FINAL DRAINAGE REPORT
CENTRAL & EUBANK CORNERSTORE
CENTRAL AVENUE & EUBANK BOULEVARD
CITY OF ALBUQUERQUE, NEW MEXICO
SEPTEMBER, 1991

REVISED SEPTEMBER 24, 1991

RE: DRAINAGE PLAN FOR DIAMOND SHAMROCK @ CENTRAL & EUBANK
(L-20/D47) RECEIVED SEPTEMBER 12, 1991

GRADING & DRAINAGE PLAN

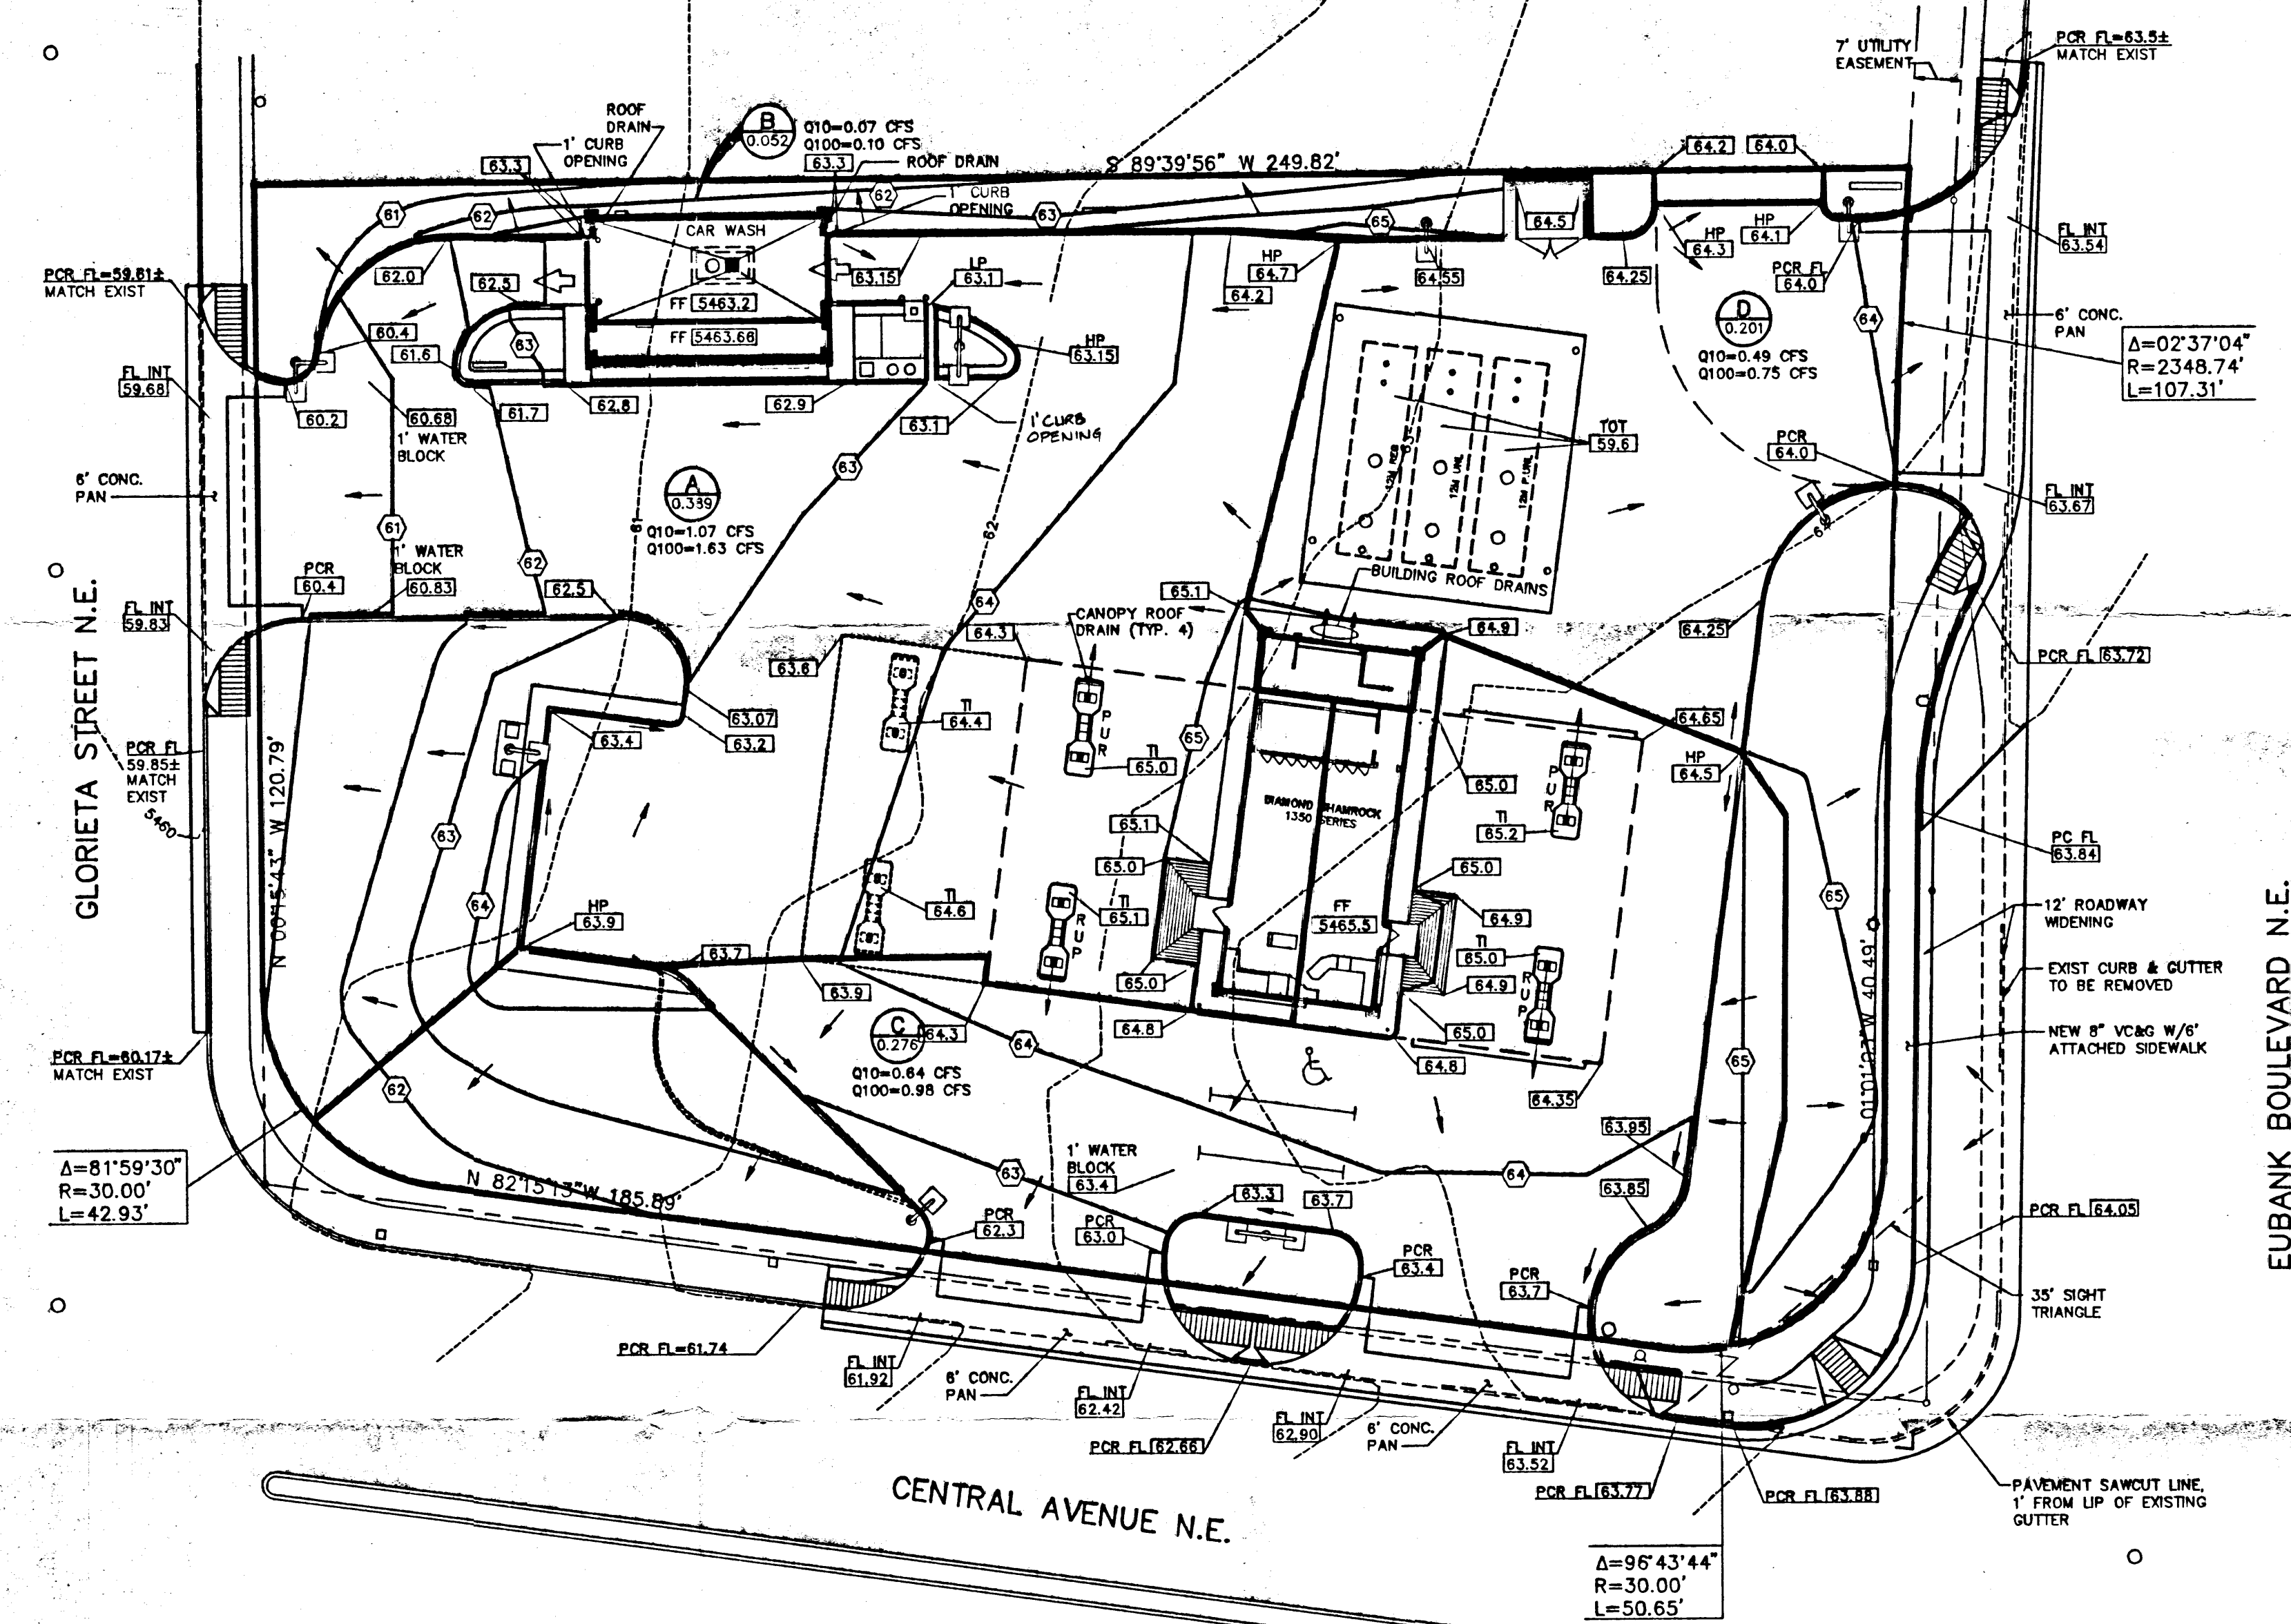
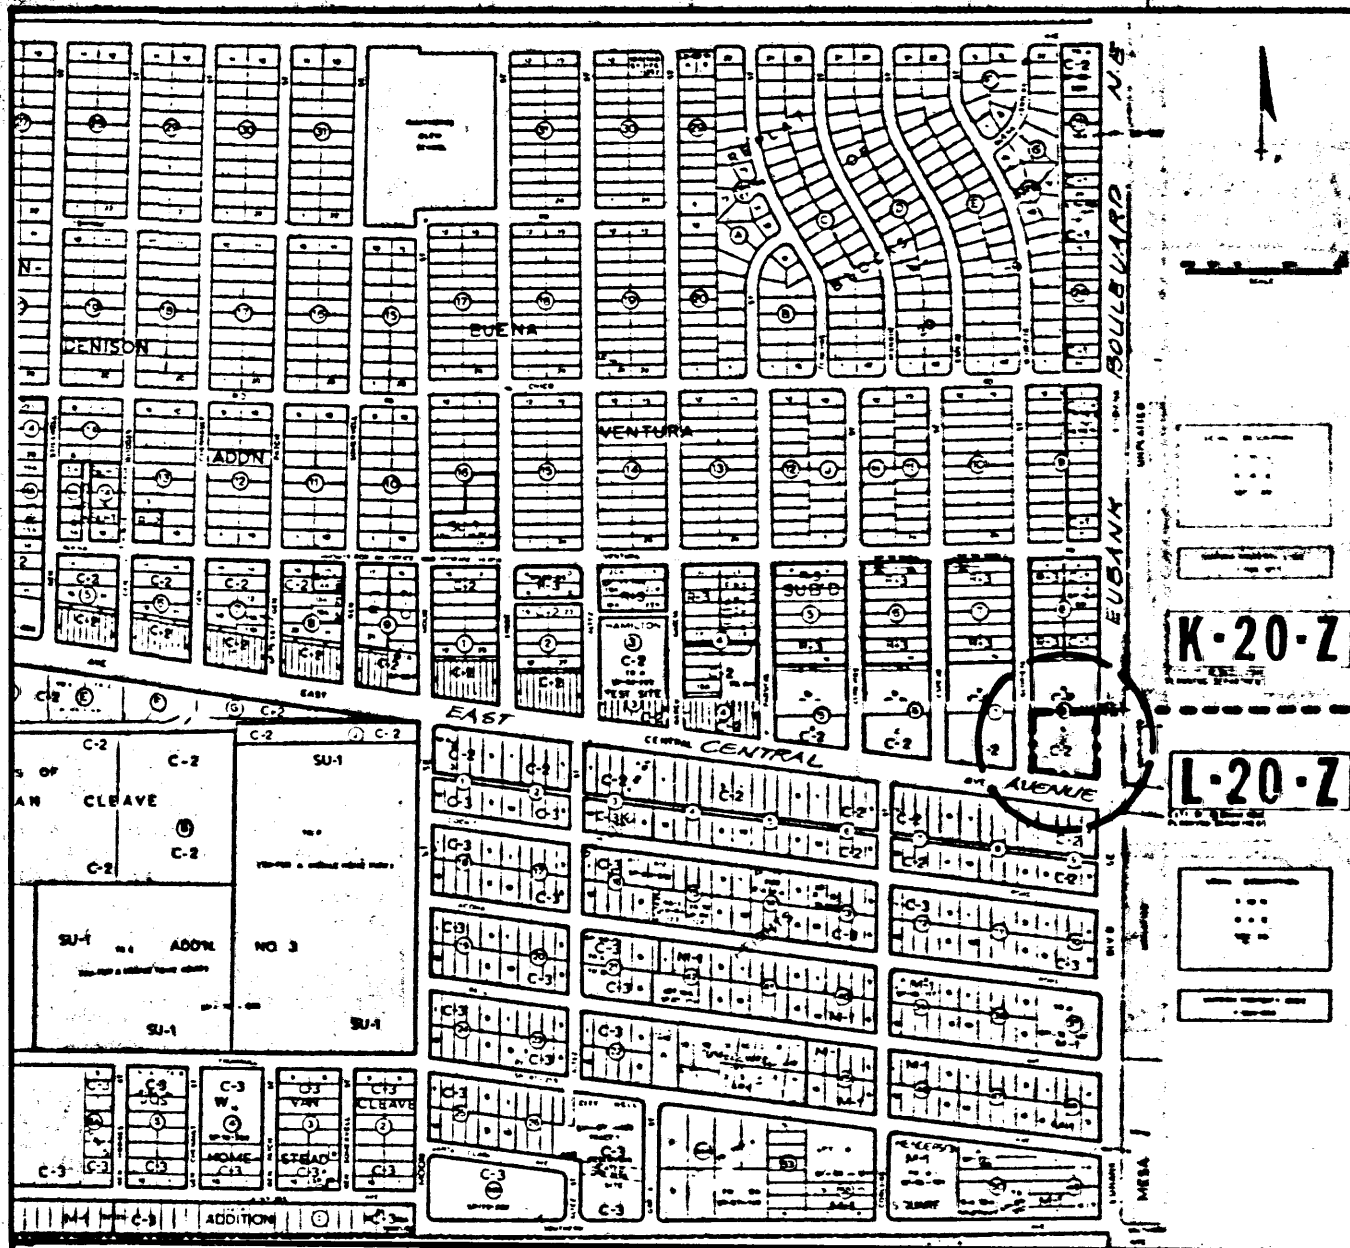
1. All finish floor elevations must be to mean sea level designation.
2. Location and direction of all roof drains.
3. Basin B developed runoff is not allowed to enter the property to the north. All developed runoff must be routed towards the asphalt area.
4. No developed runoff is allowed to cross the public sidewalk.
